**SYDNEY
REGIONAL
DEVELOPMENT
ADVISORY
COMMITTEE**

**MAJOR PROJECT APPLICATION MP10_0105 AND DA609/2010 - RESIDENTIAL
DEVELOPMENT AT 40 WALKER STREET, RHODES**

I refer to Council's correspondence dated 15 December 2010 with regard to the above-mentioned development application, which was referred to the Roads and Traffic Authority (RTA) for comment in accordance with Part 3A of the *Environmental Planning and Assessment Act 1979*. I wish to advise that the Sydney Regional Development Advisory Committee (SRDAC) discussed the proposed development at its meeting held on 12 January 2011 and provides the following comments:

4410 A-0201 A

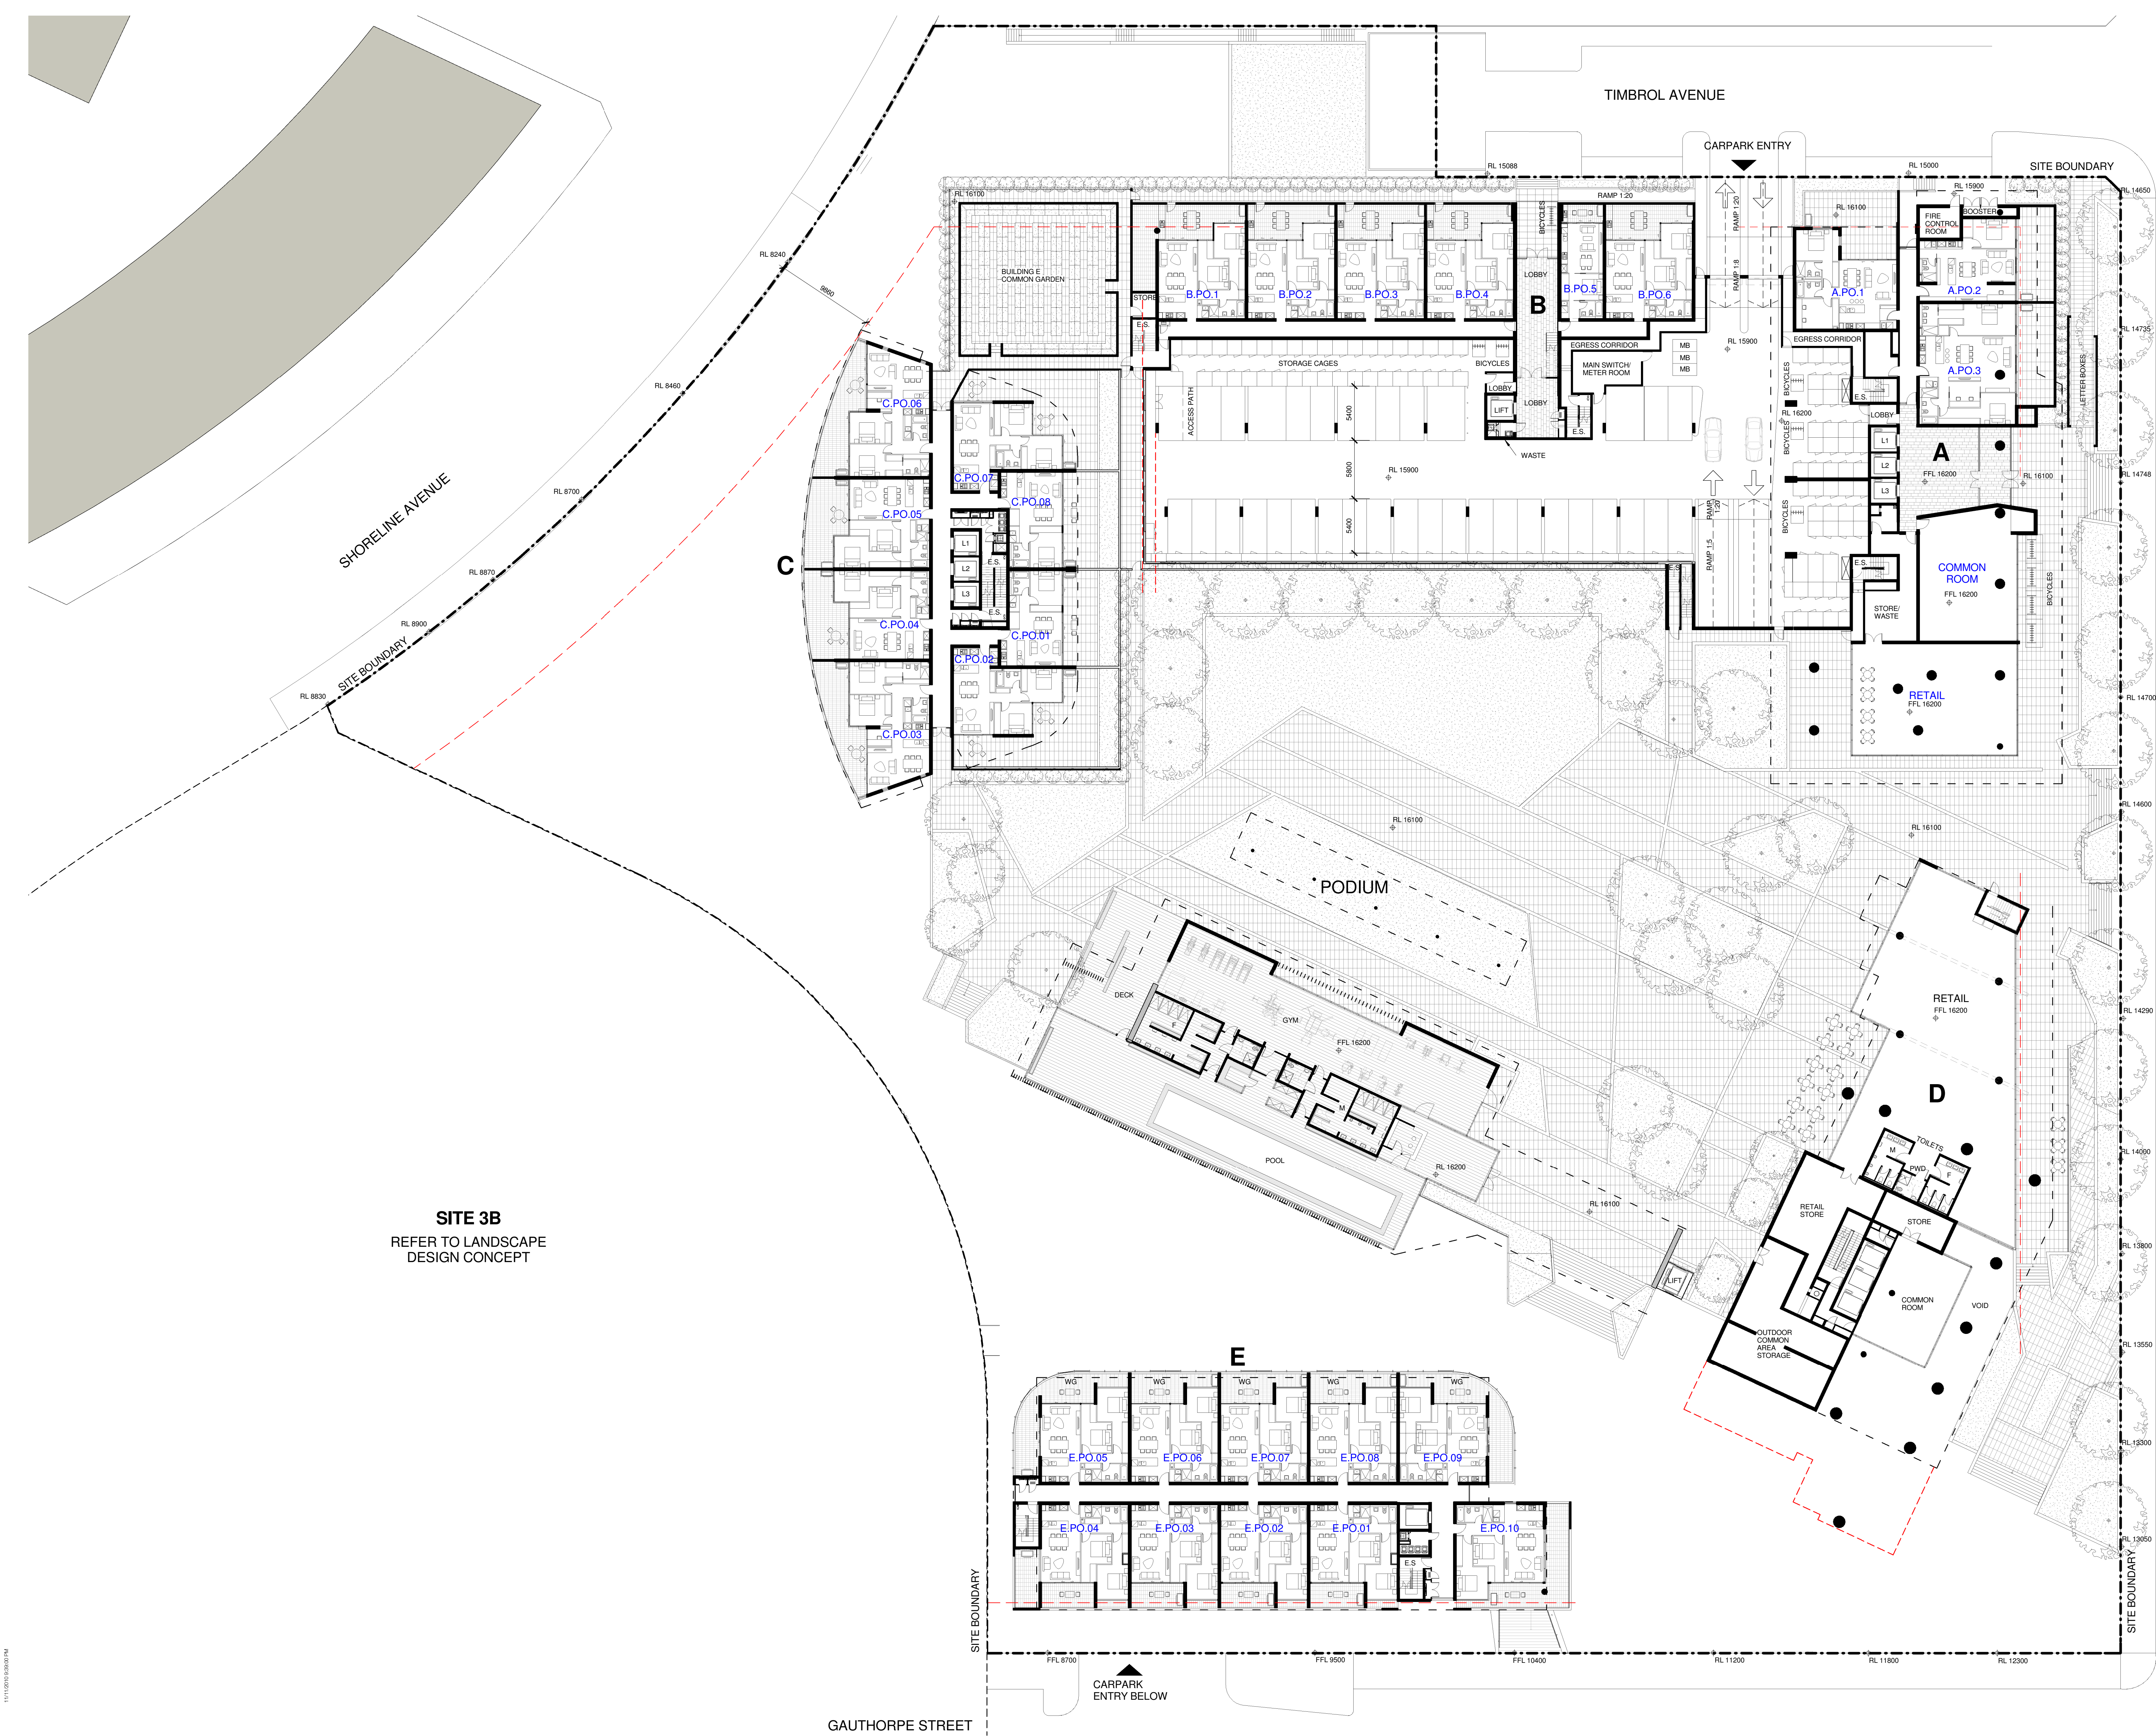
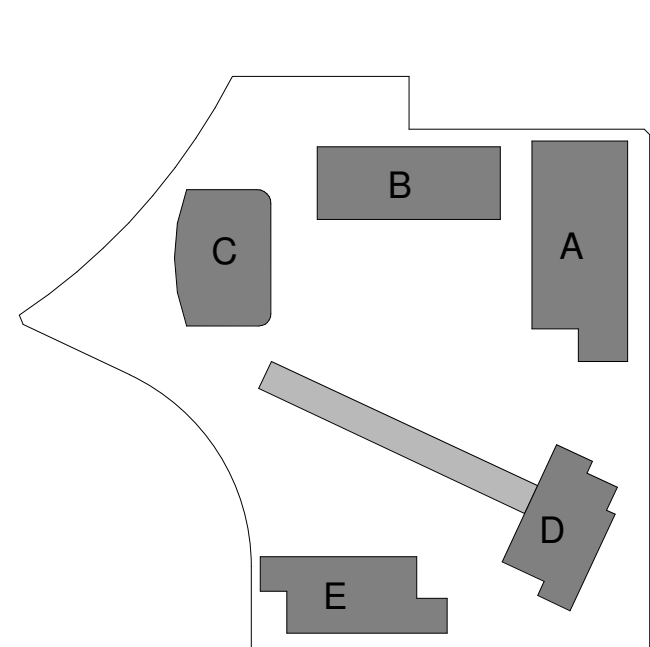
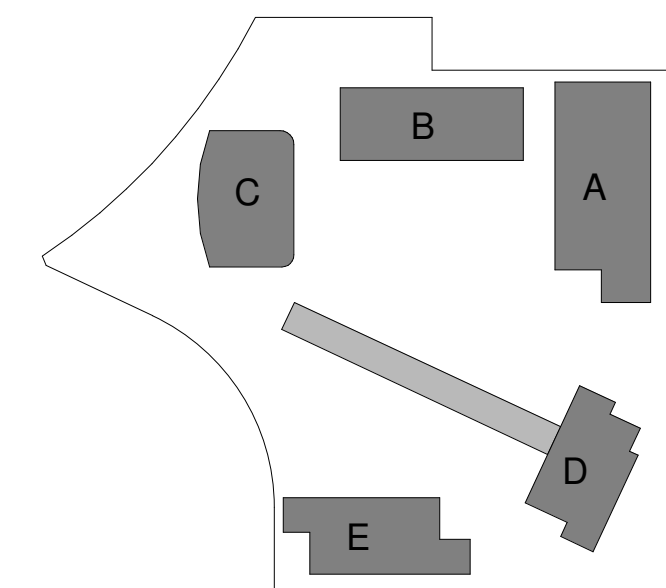
2. The maximum car parking spaces provided for each unit shall be restricted to average one car parking space for one residential unit.

6. The swept path of the longest vehicle (including garbage trucks) entering and exiting the subject site, as well as manoeuvrability through the site, shall be in accordance with AUSTRROADS, AS 2890.1 - 2004 and AS 2890.2 – 2002. In this regard, a plan shall be submitted to Council for approval, which shows that the proposed development complies with this requirement.

11. AS 2890.1 - 2004, Clause 3.3 (a) for property line / building alignment / pedestrian path, permits a maximum gradient of 1 in 20 (5%) between edge of frontage road and the property line, building alignment or pedestrian path for at least the first 6 metres into the car park. Council should ensure that the gradients provided for the development complies with AS 2890.1 - 2004.

12. Clear sight lines shall be provided at the property boundary line to ensure adequate visibility between vehicles leaving the car park and pedestrians along the frontage road footpath in accordance with Figure 3.3 of AS 2890.1 - 2004 for light vehicles and AS 2890.2 - 2002 for heavy vehicles.
